CITY OF ALBUQUERQUE

**Re: Urology Network of New Mexico, 610 Broadway Blvd NE, Grading and
Drainage Plan**
Engineer's Stamp dated 9-17-04 (J14-D148)

DRAINAGE AND
GRADING PLAN

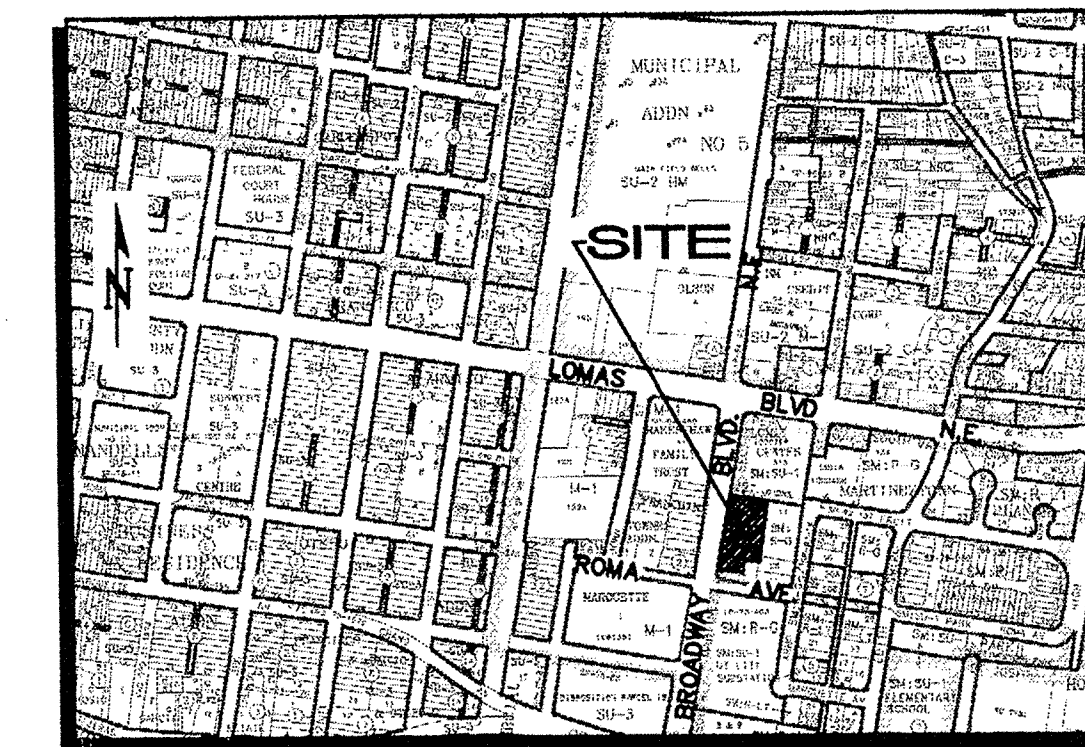
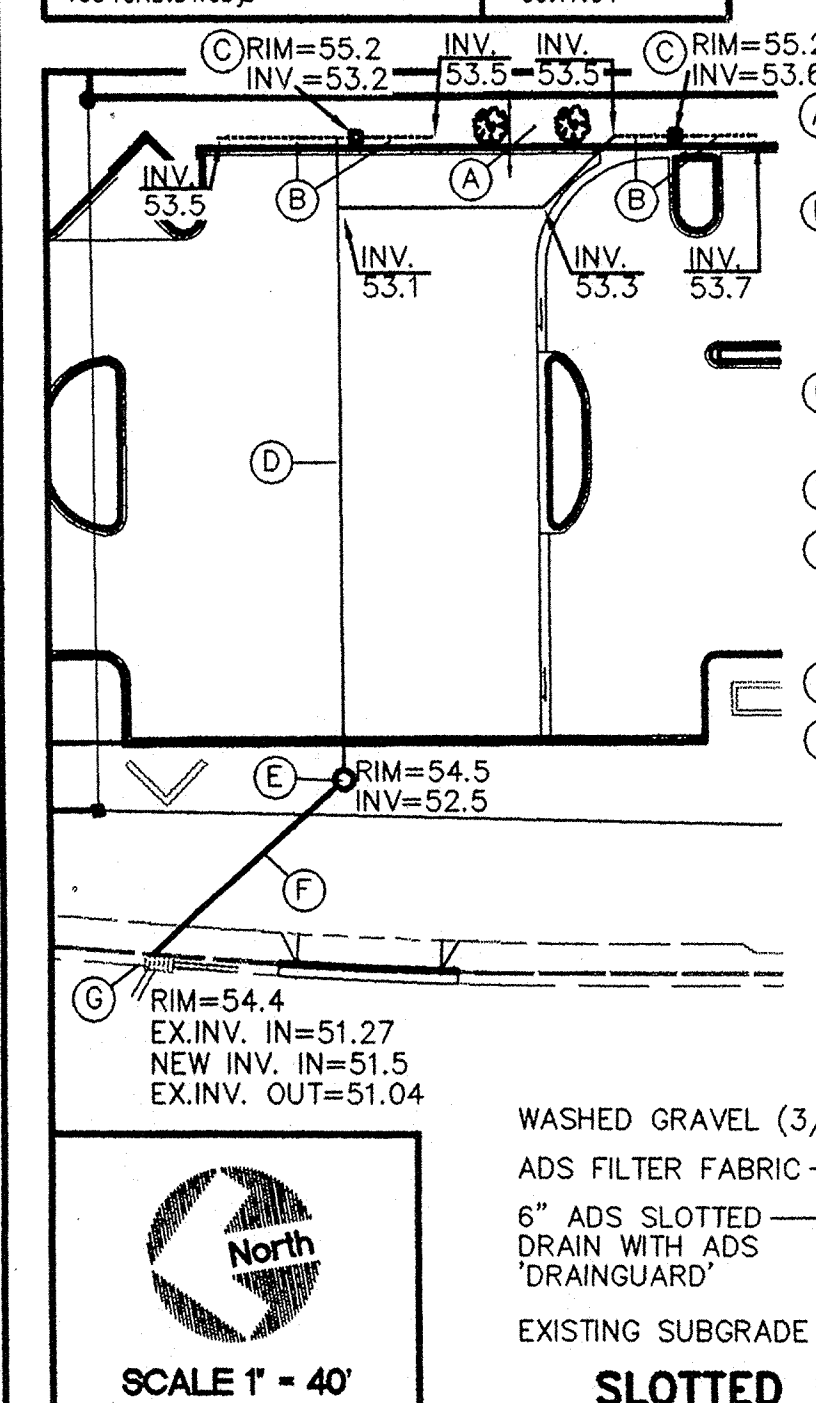
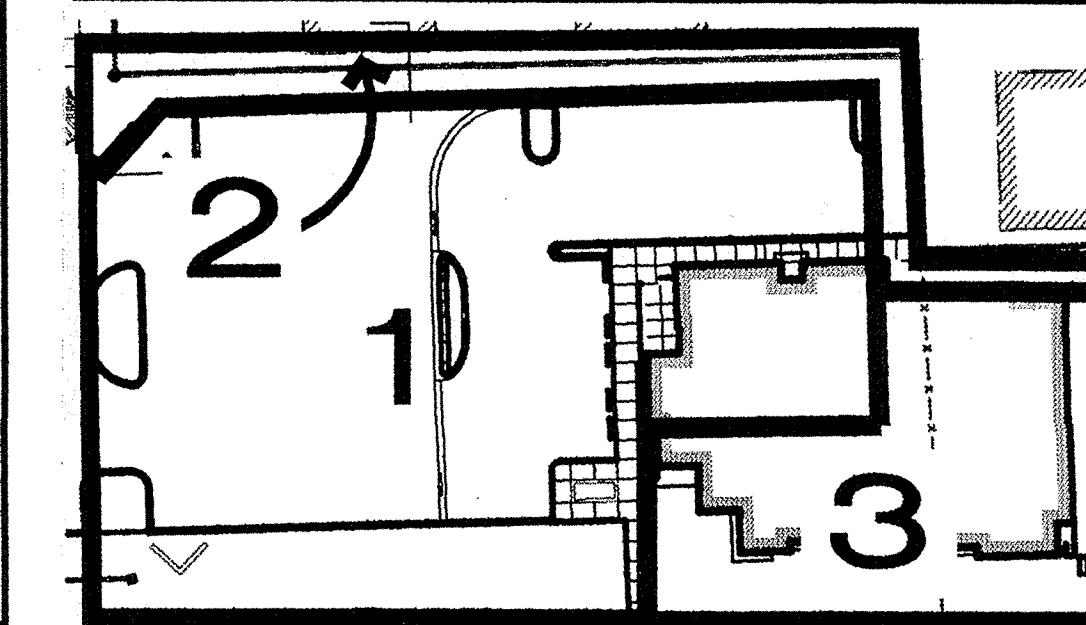
1. Ponding / Water Harvesting is not allowed within the City Right of Way.
2. Please include a copy of the drainage calculations.
3. Where is the proposed storm drain detail referred to in note 17?
